**Re: Country Club Place - Lot 2 - Phase I, 1900 Central Ave SW,
Request for Permanent C.O. –Accepted
Engineer's Stamp dated: 04-05-11, (J13/D011)
Certification dated: 10-03-12**

DRAINAGE AND TRANSPORTATION INFORMATION SHEET
(Rev. 12/05)

PROJECT TITLE: Country Club Place ZONE MAP/DRG.FILE# J-13/D011
DRB#: _____ EPC#: _____ WORK ORDER#: 752083

sheet  
**CG-101**

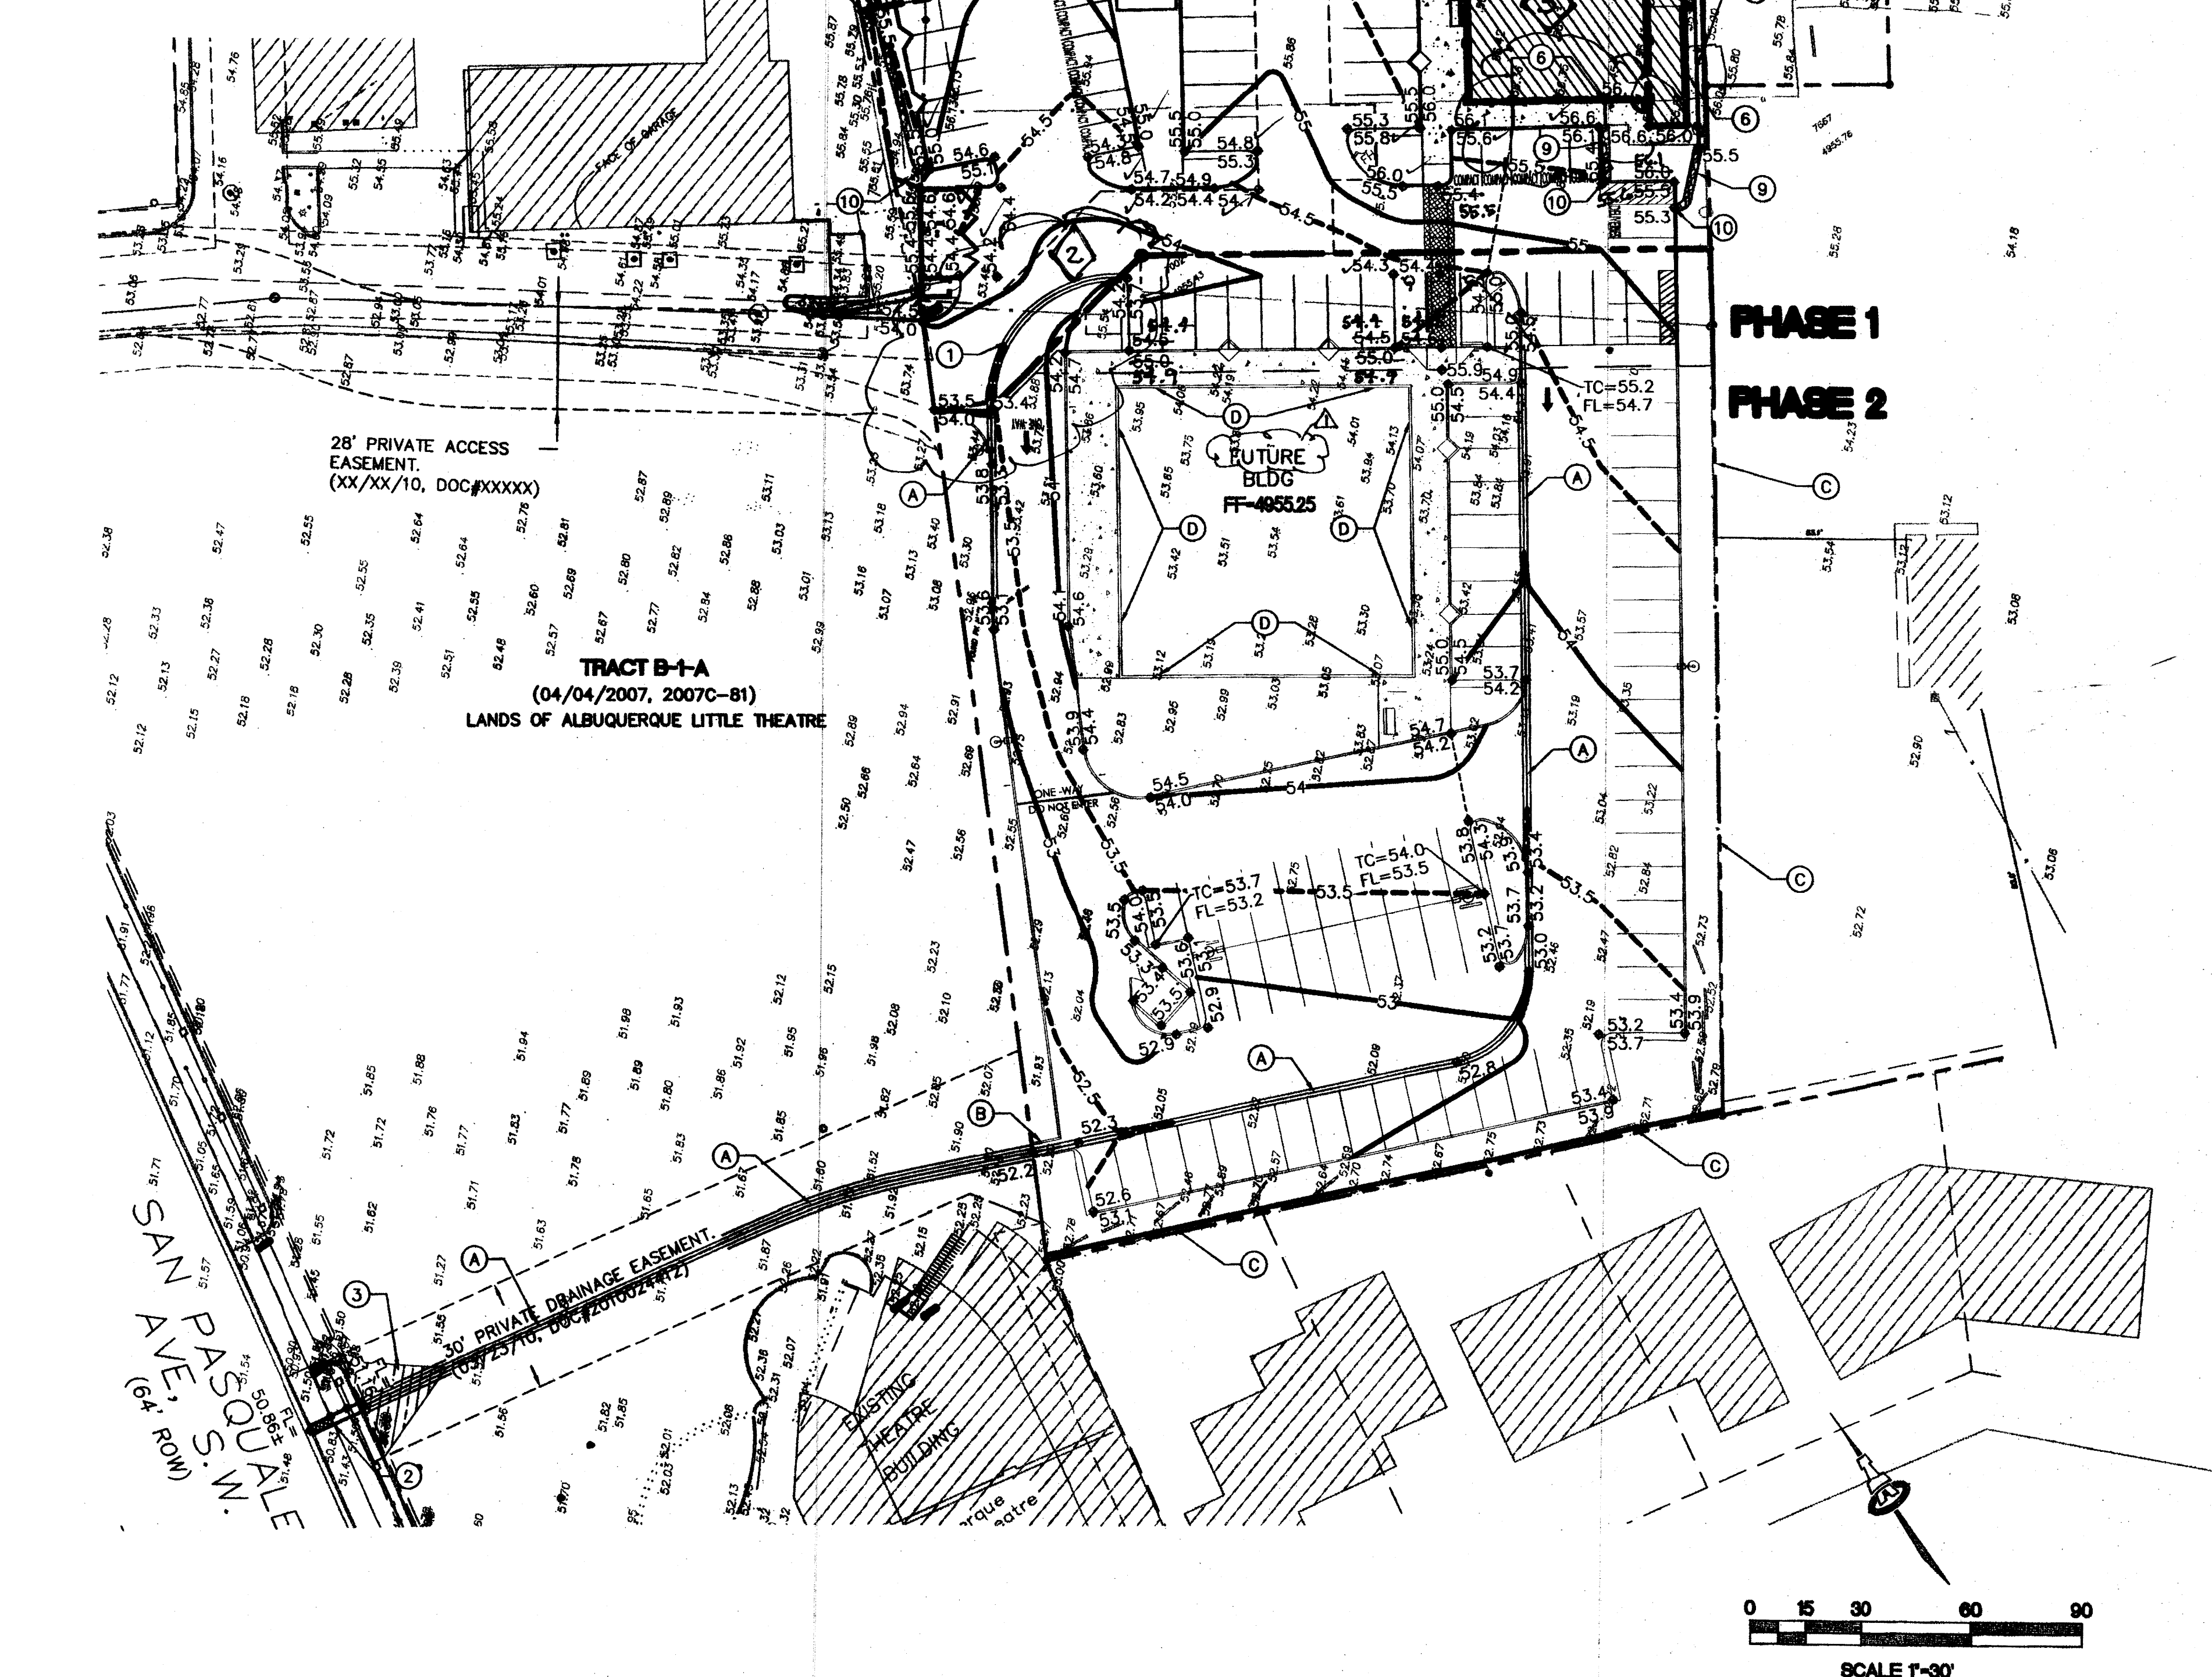
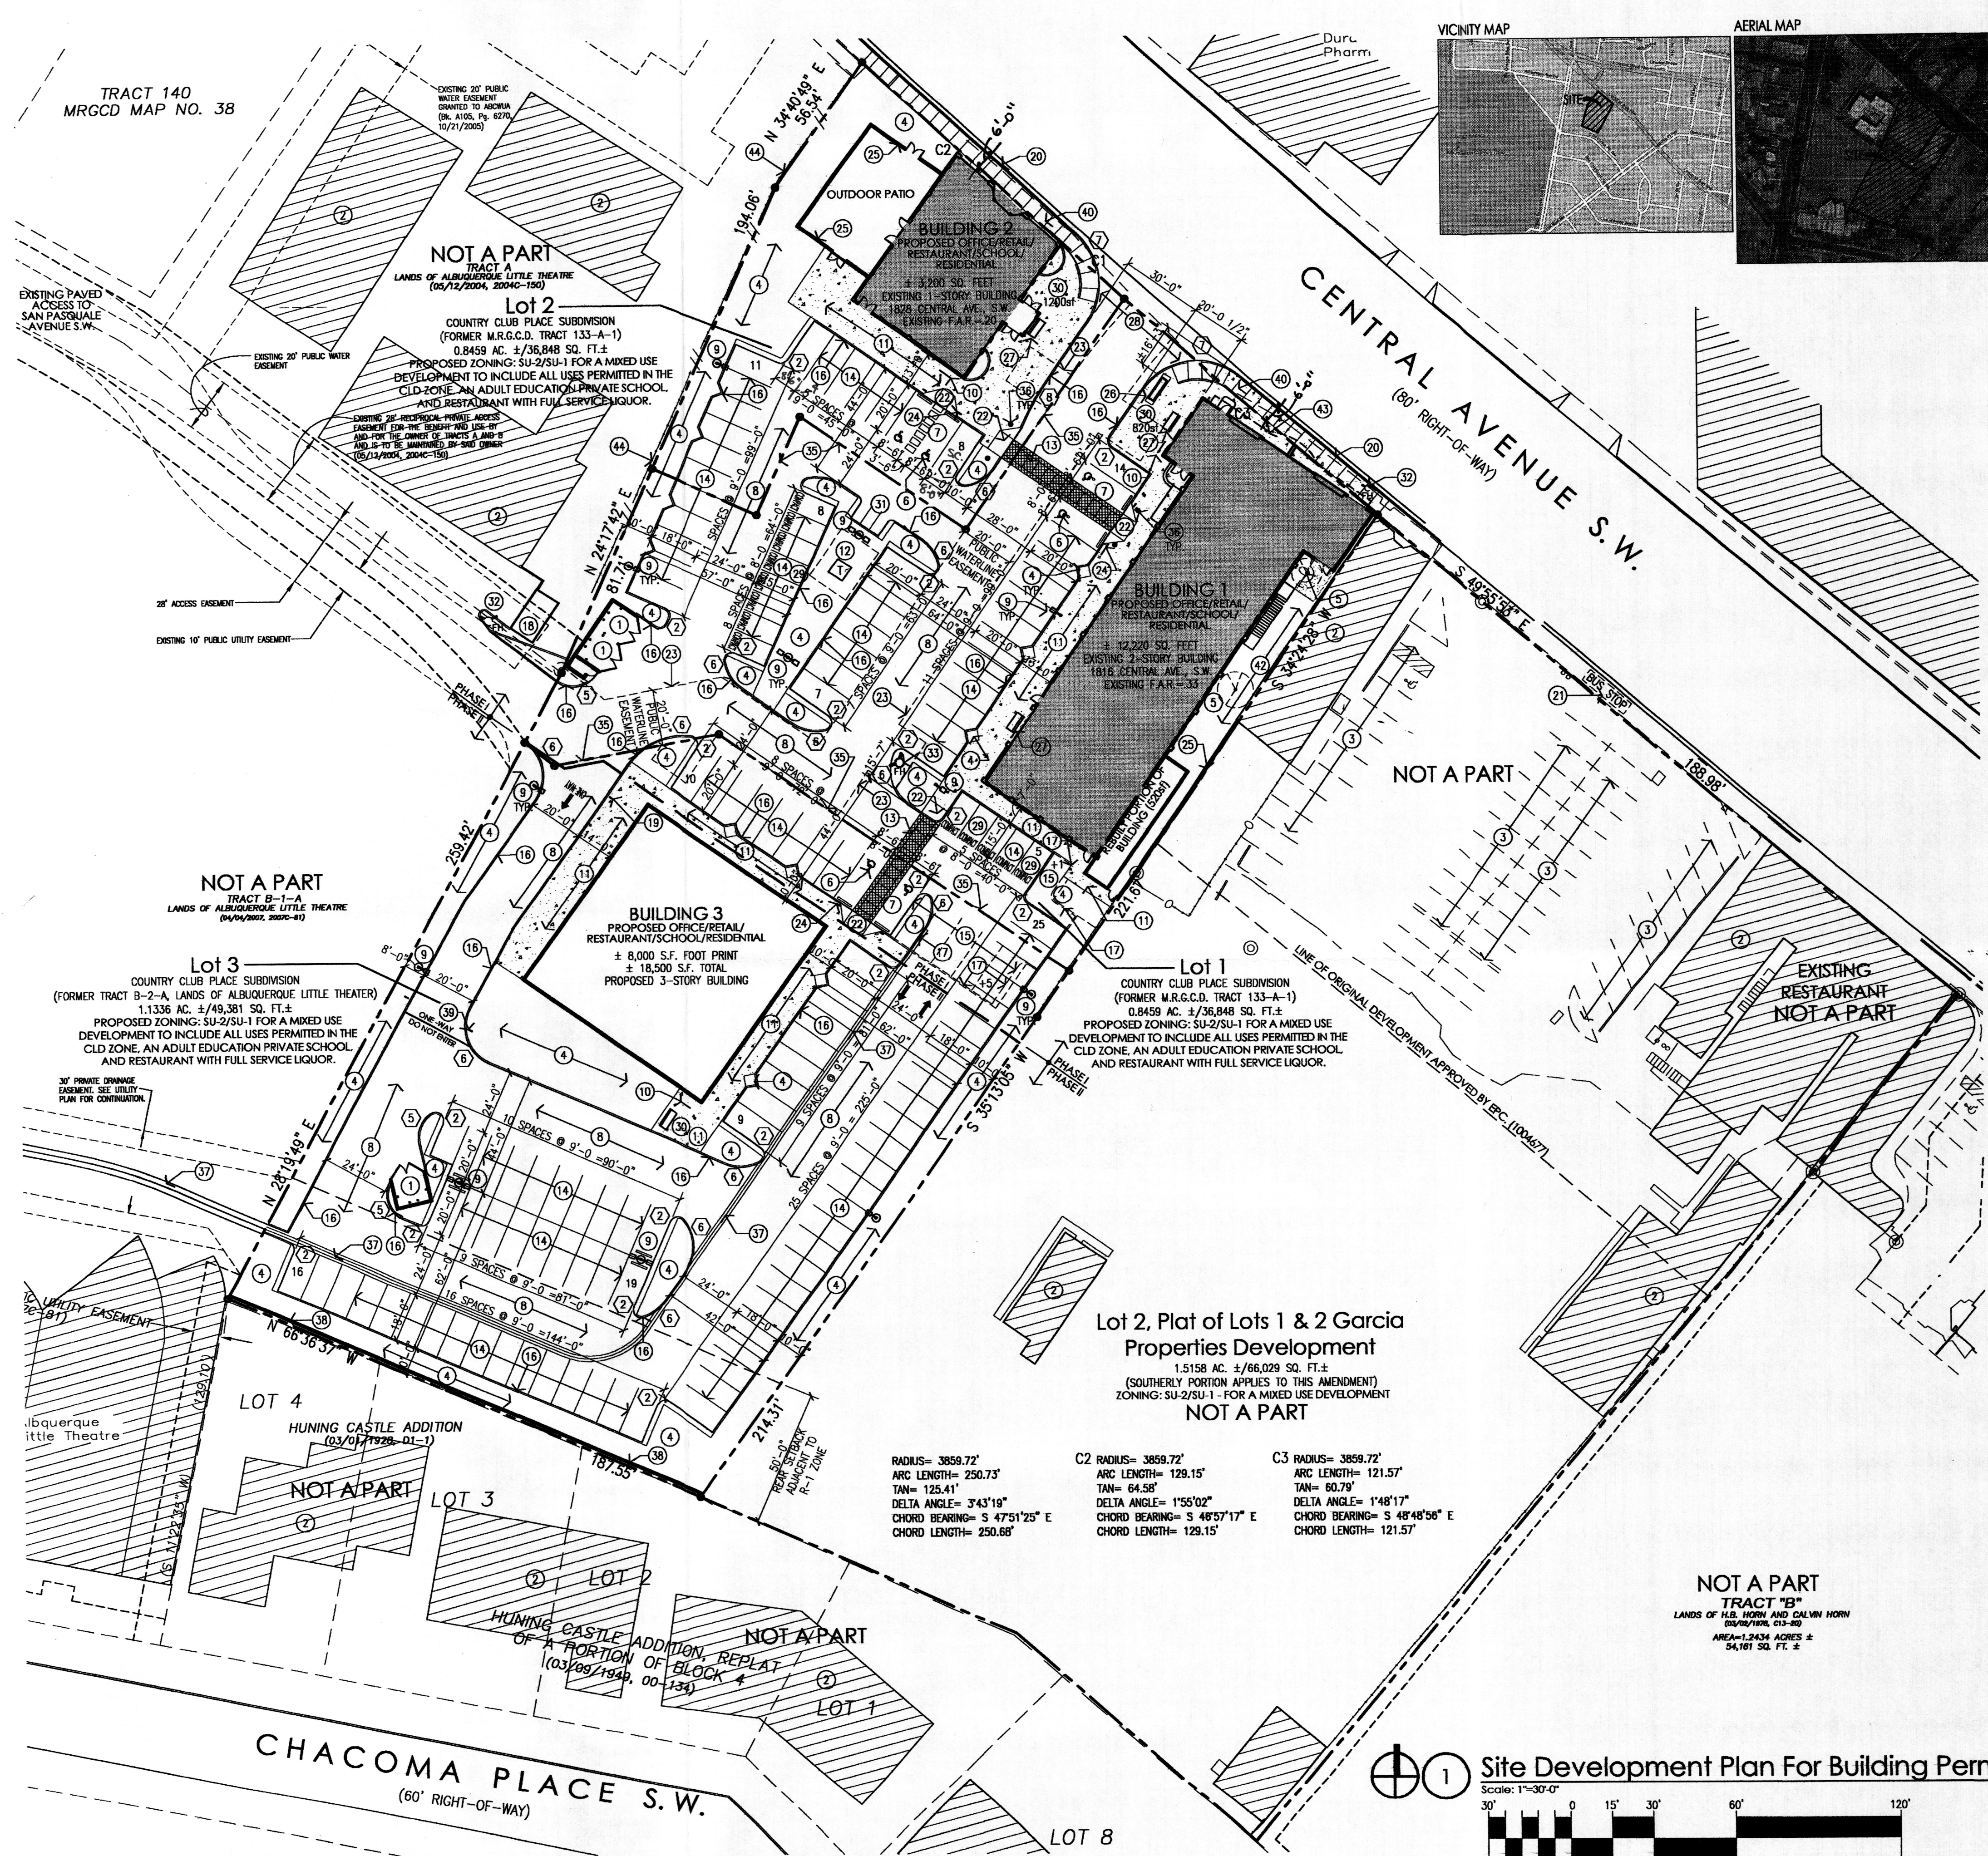
- The "New Building" needs to be changed to read "Future Building".

2. add a ^{bullet} ~~bullet~~ that in her Certificate
she should change now to Future
in the south Bldg.

# **WESTERN BUILDING DRAINAGE CERTIFICATION**

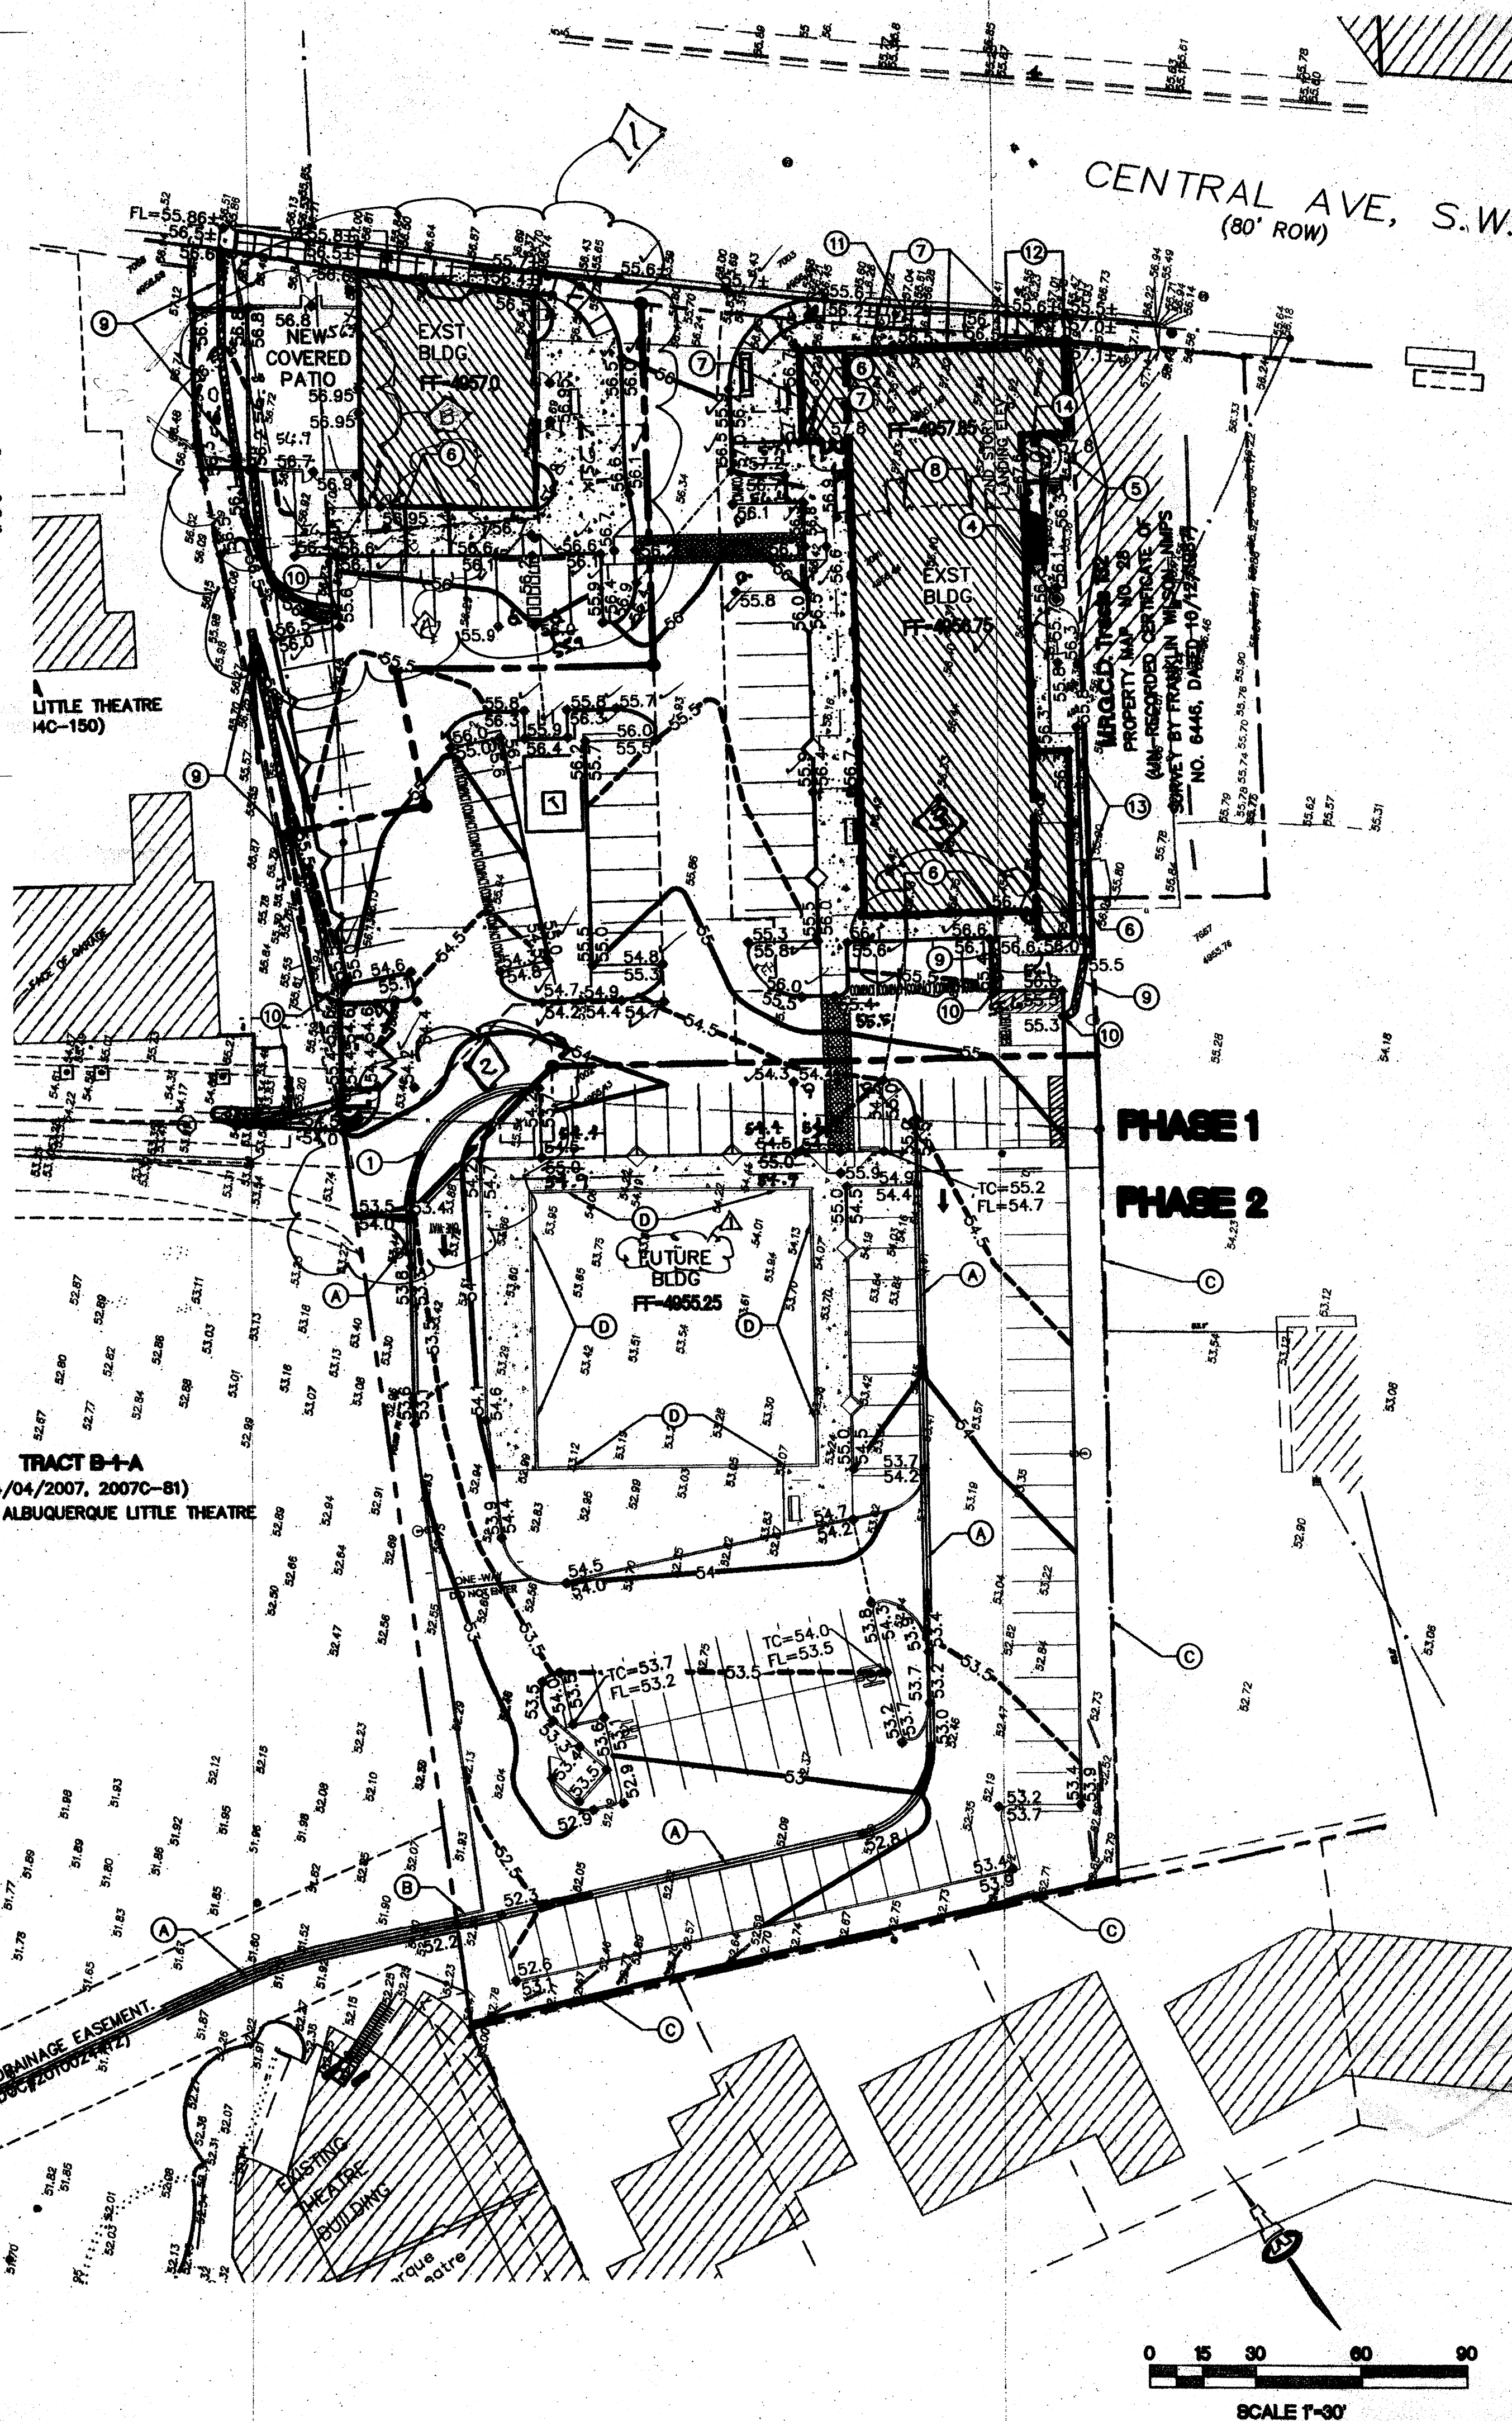
When submitting for Permanent CO for the West Building, Market Fresh, the following items are to be addressed:

- The drainage addressed in Certification Note 2 is to drain south or an easement and capacity analysis to drain west/not per plan is required.
- Keyed Note 13 is to be changed to what is built or the trench drain is to be built.
- The sidewalk culvert on San Pasquale is to be constructed.
